Our Ref: Y/6/19/HH
Your Ref:

Town & Country Planning Act 1990 (as amended)
Town & country Planning (Development Management Procedure) (England) Order 2015
Application for Planning Permission for Works or Extension to a Dwelling

Development Construction of Swimming pool, surround.
Location Bonhams Farm House Main Road Yapton

BLOCK PLAN 1:500

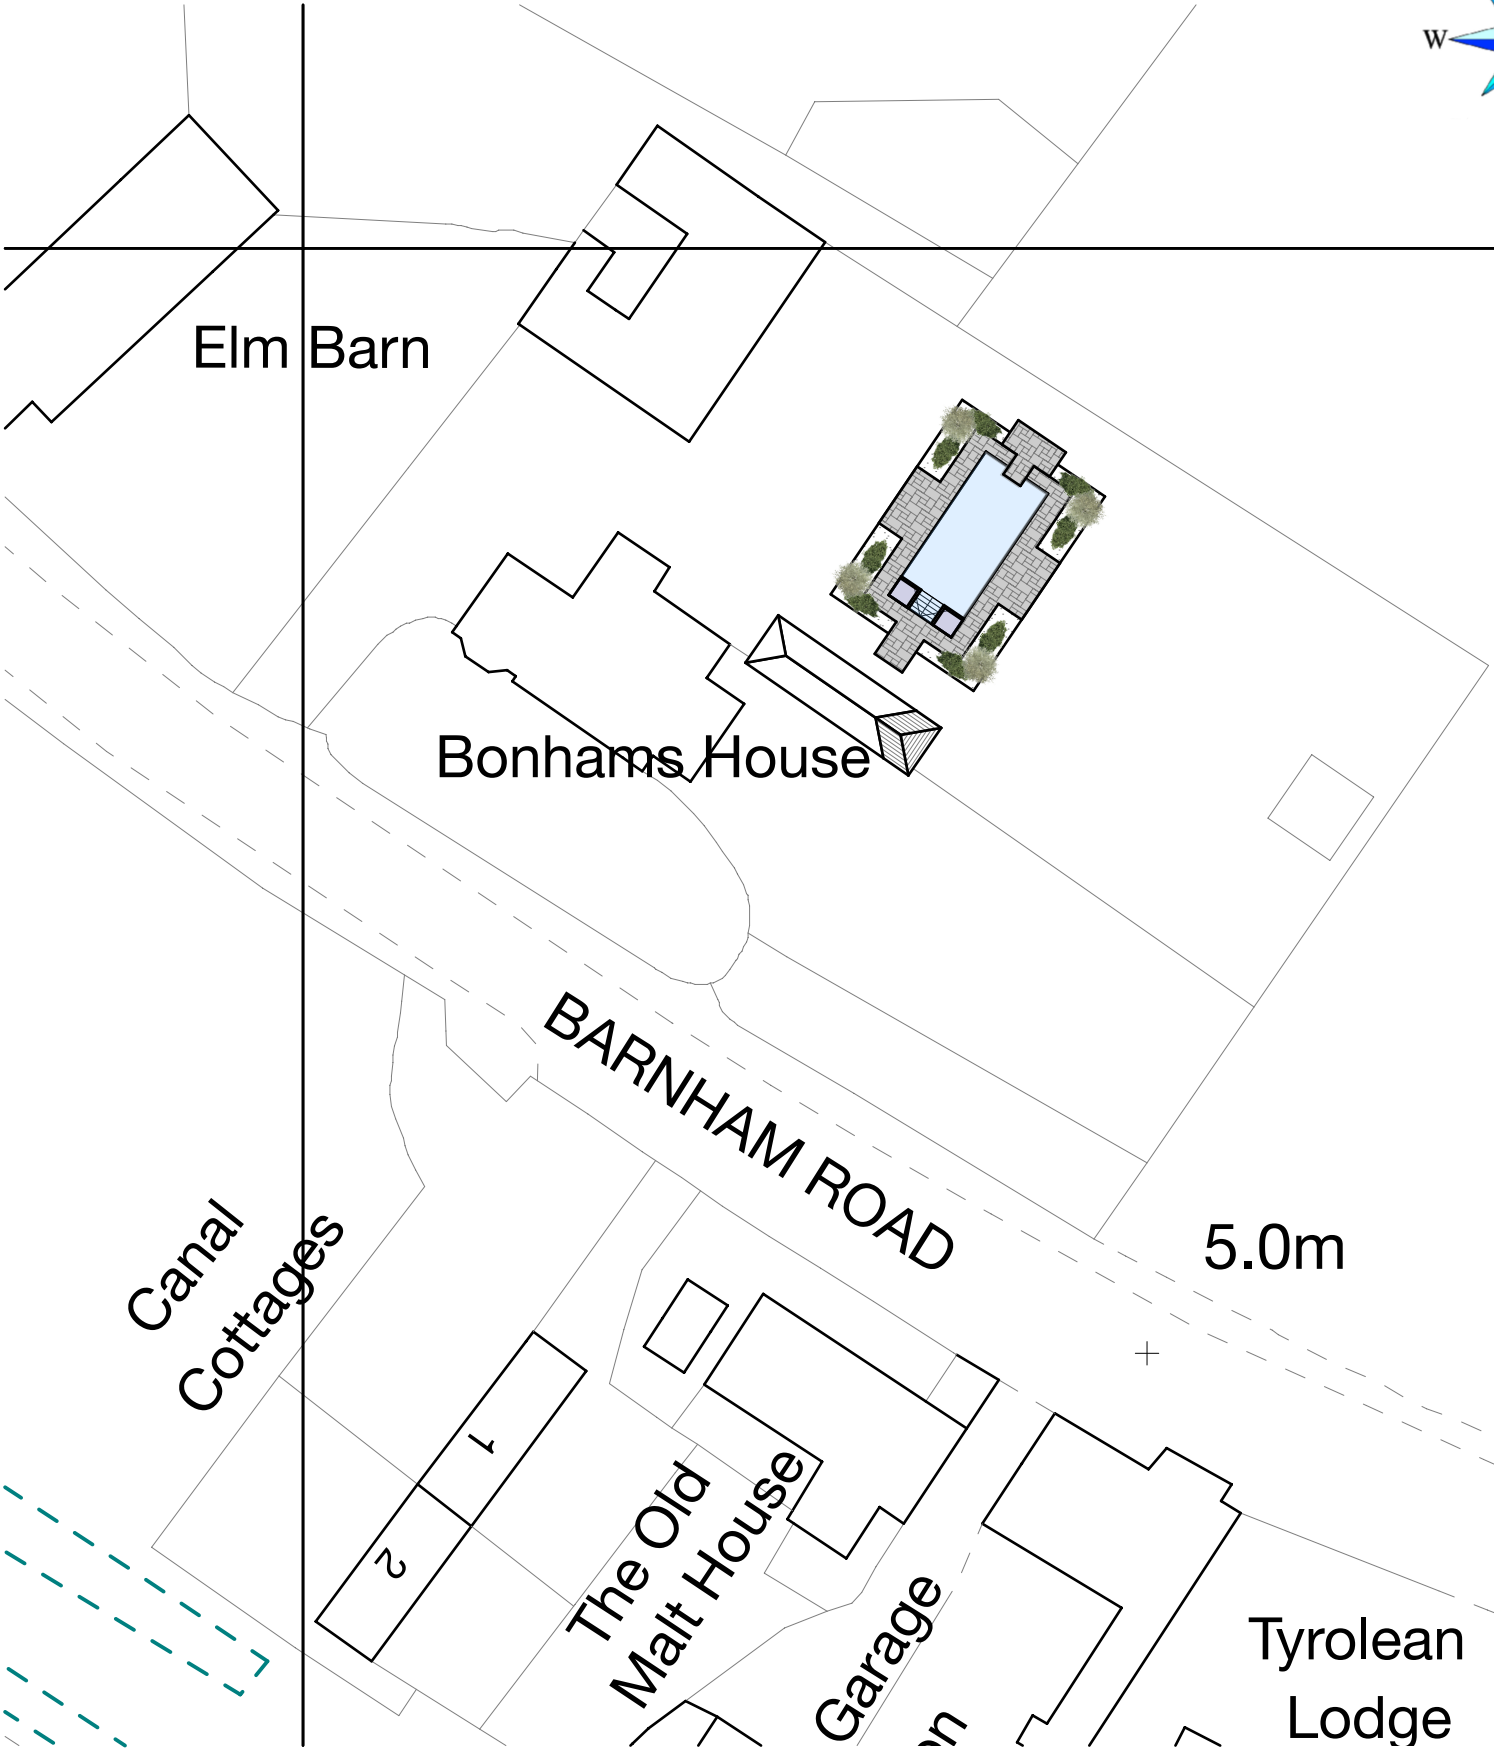
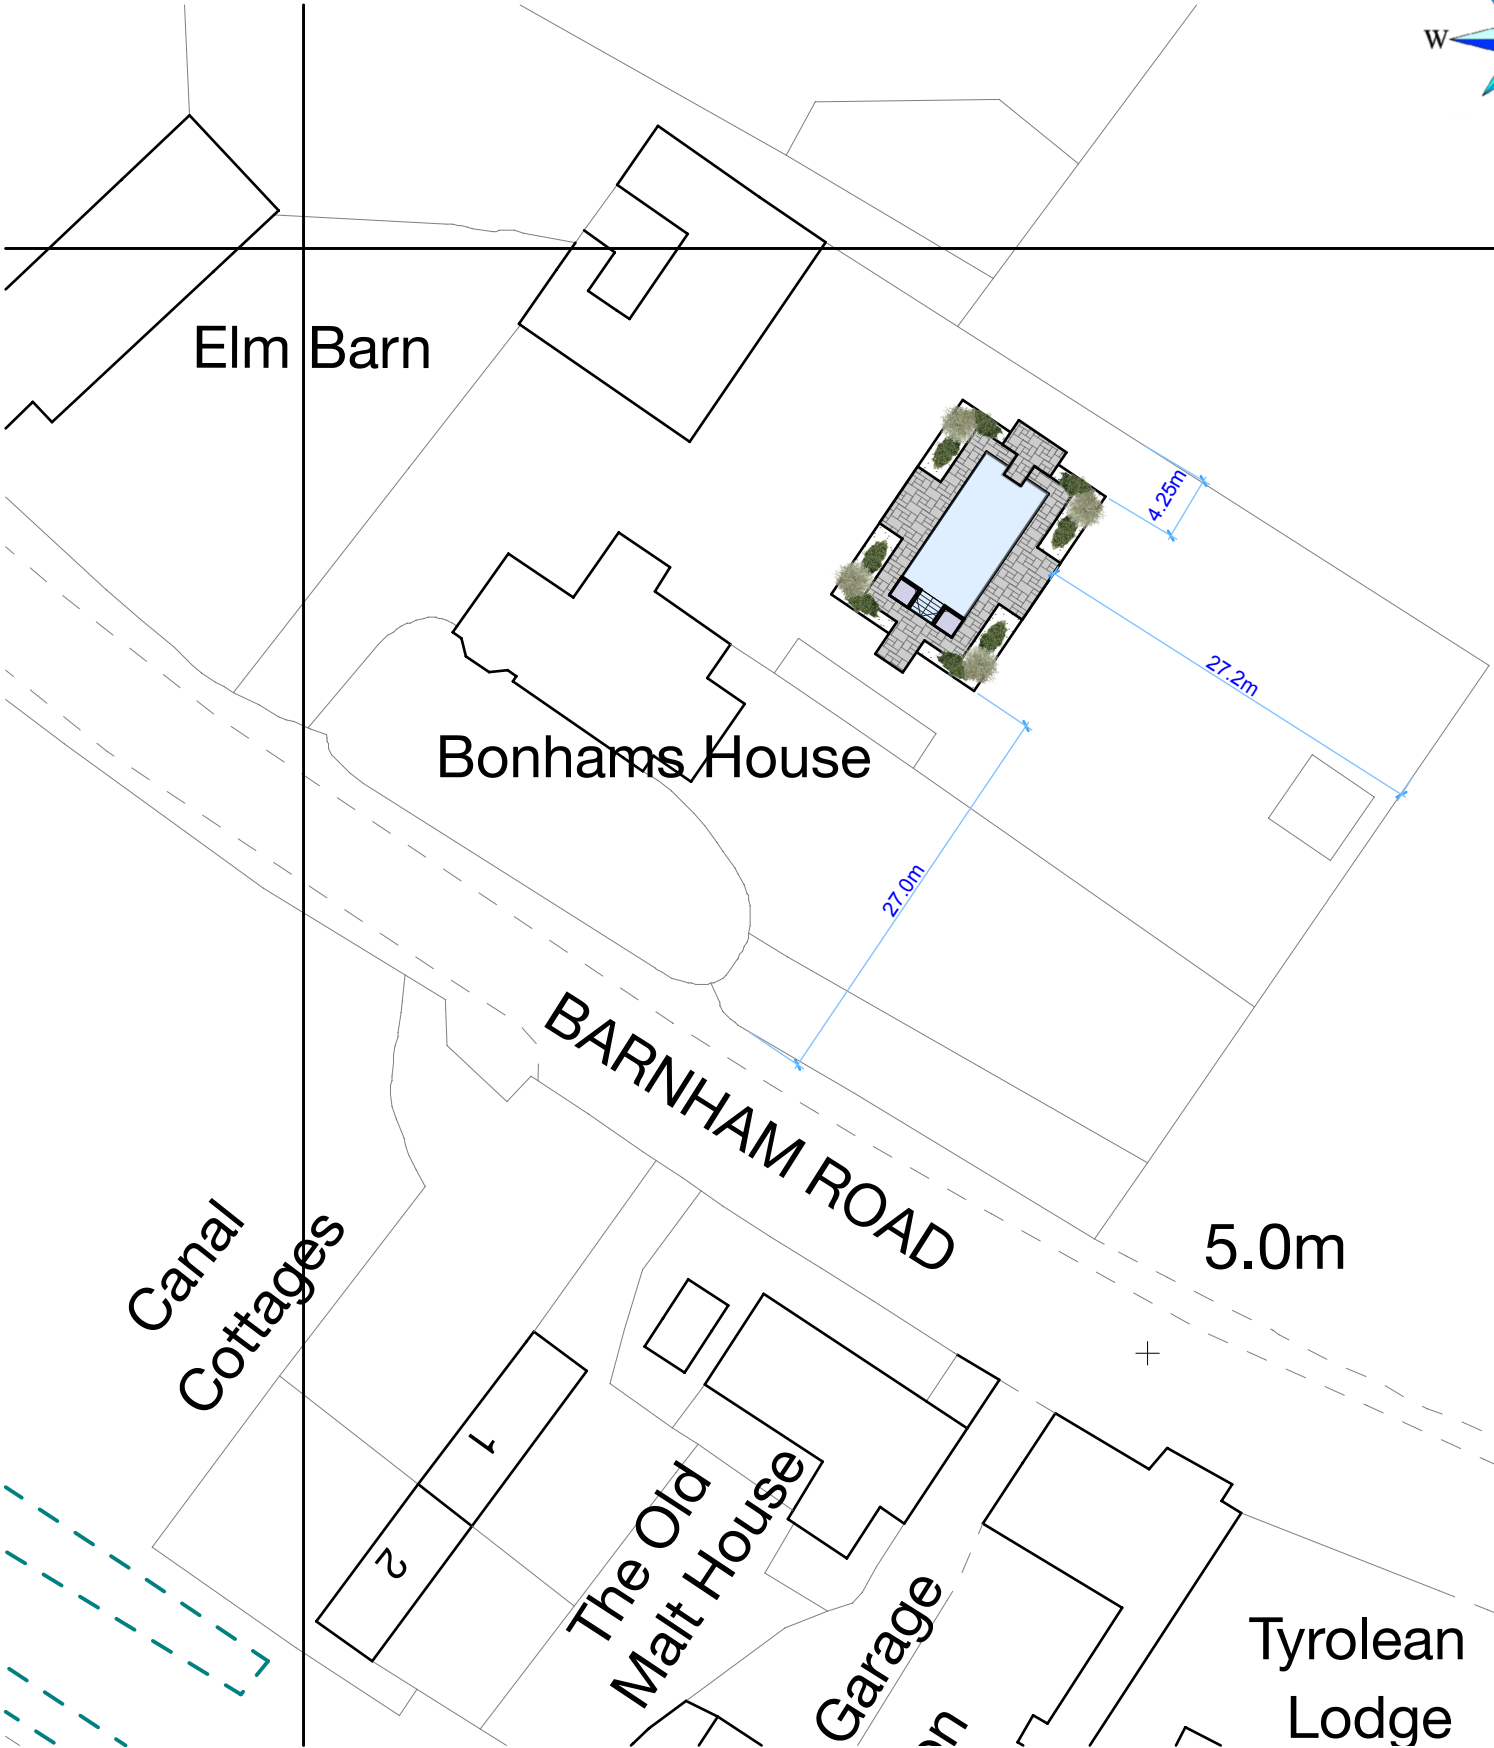
Block Plan

Please submit 1 electronic or 3 paper copies of a block/site plan which includes all dimensions from the proposal to the site boundaries. Further details of what must be included on the plan can be found in the National Validation Requirements.
